**Re: Lot 2 Block 3 Unit 18 Volcano Cliffs, S.A.D. 228  
6612 Cuervo Pl NW  
Request Permanent C.O. – Accepted  
Engineer's Stamp Date: 10-29-19 (D10D003S2)  
Revised Certification dated: 8/27/2020**

**Re: Lot 2 Block 3 Unit 18 Volcano Cliffs, S.A.D. 228  
6612 Cuervo Pl NW  
Request for Permanent C.O. – Not Accepted  
Engineer's Stamp Dated: 10-29-19 (D0D003S2)  
Certification dated: 6/12/2020**

JOHNSON (MIKE SANCHEZ) - 6612 CUERVO GRADING & DRAINAGE PLAN

JOHNSON (MIKE SANCHEZ) - 6612 CUERVO GRADING & DRAINAGE PLAN

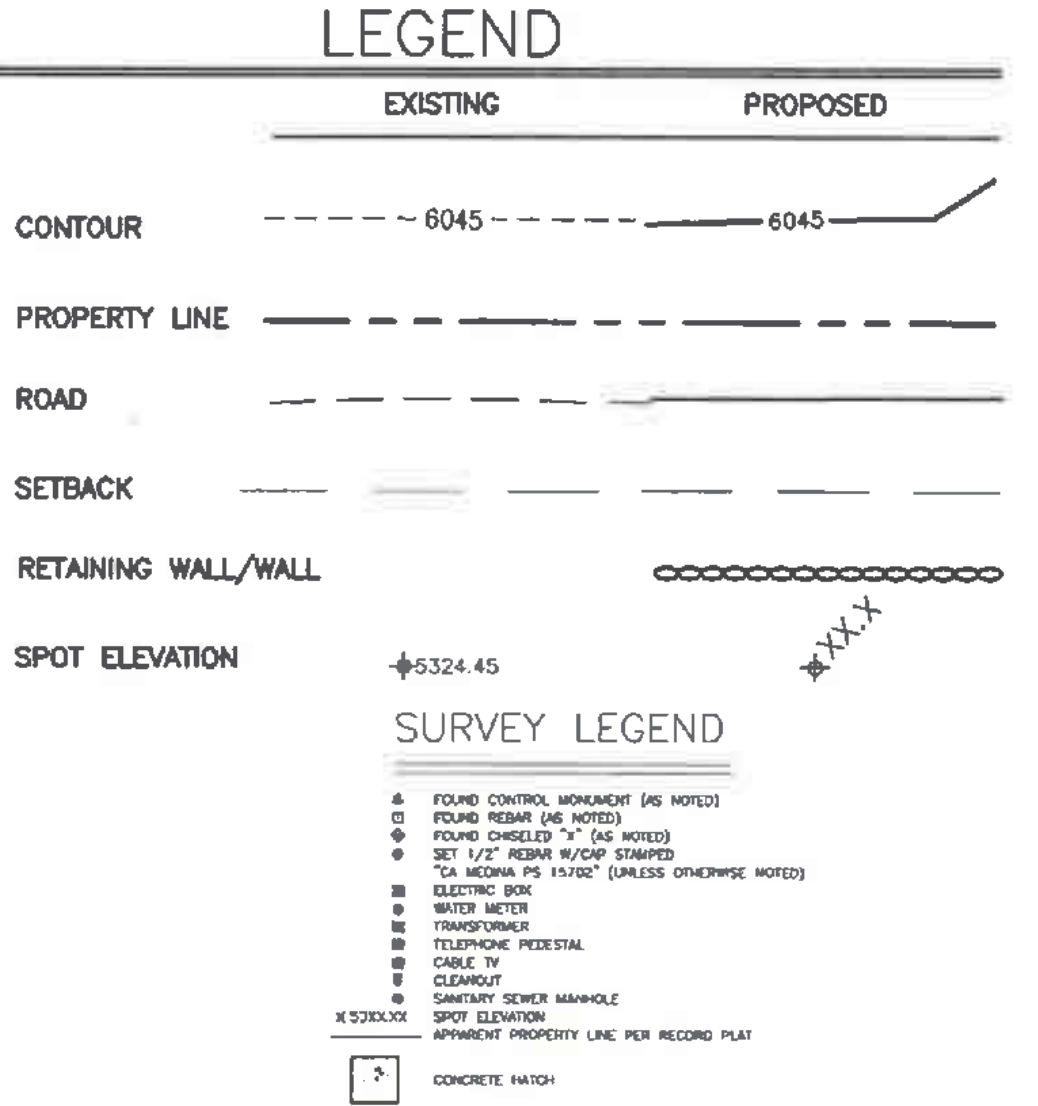
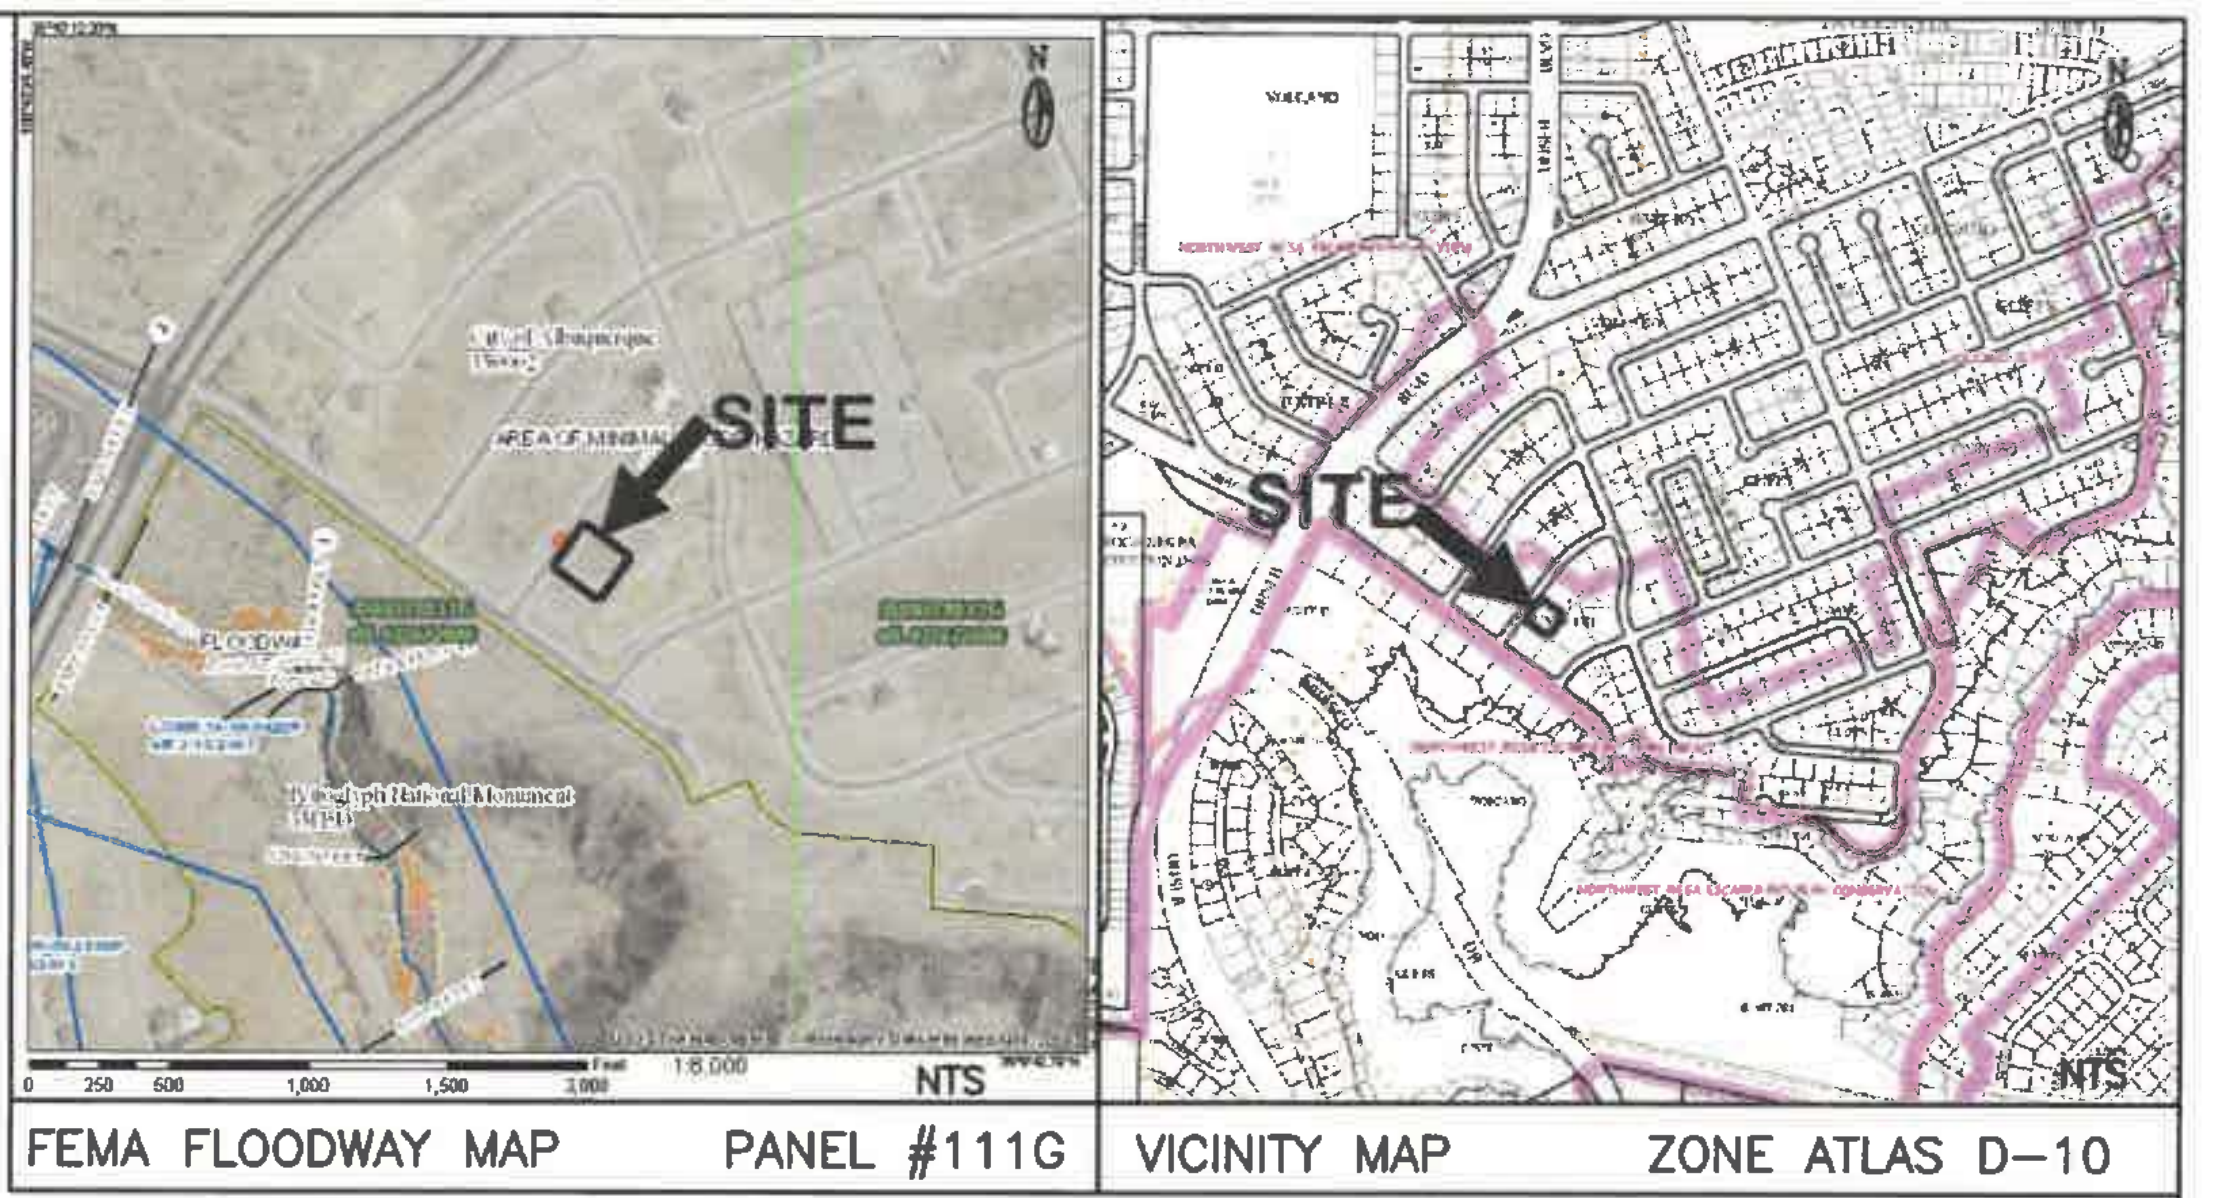
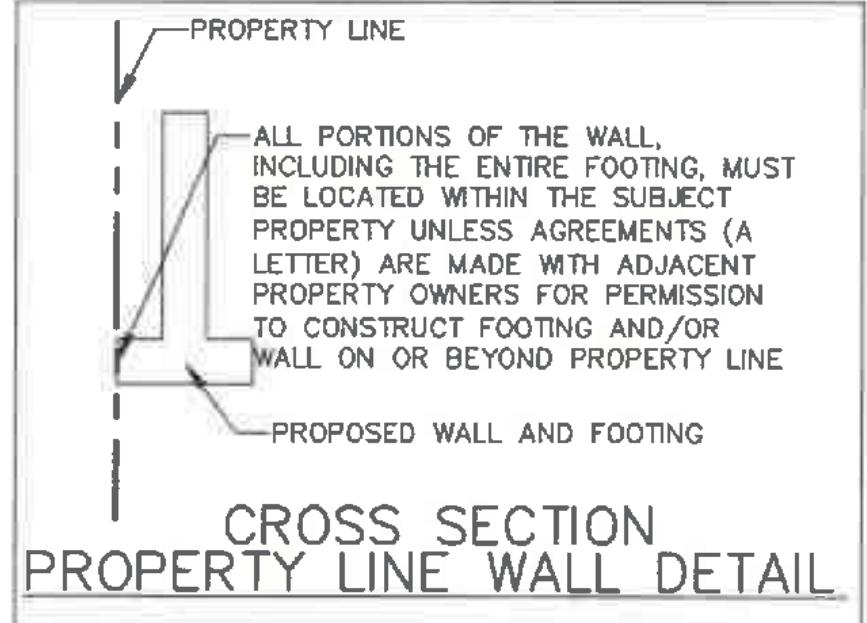
- Provide how erosion will be prevented on the east side of property, outside the block wall. **the owner will be placing native grass seeding per COA spec 1012**
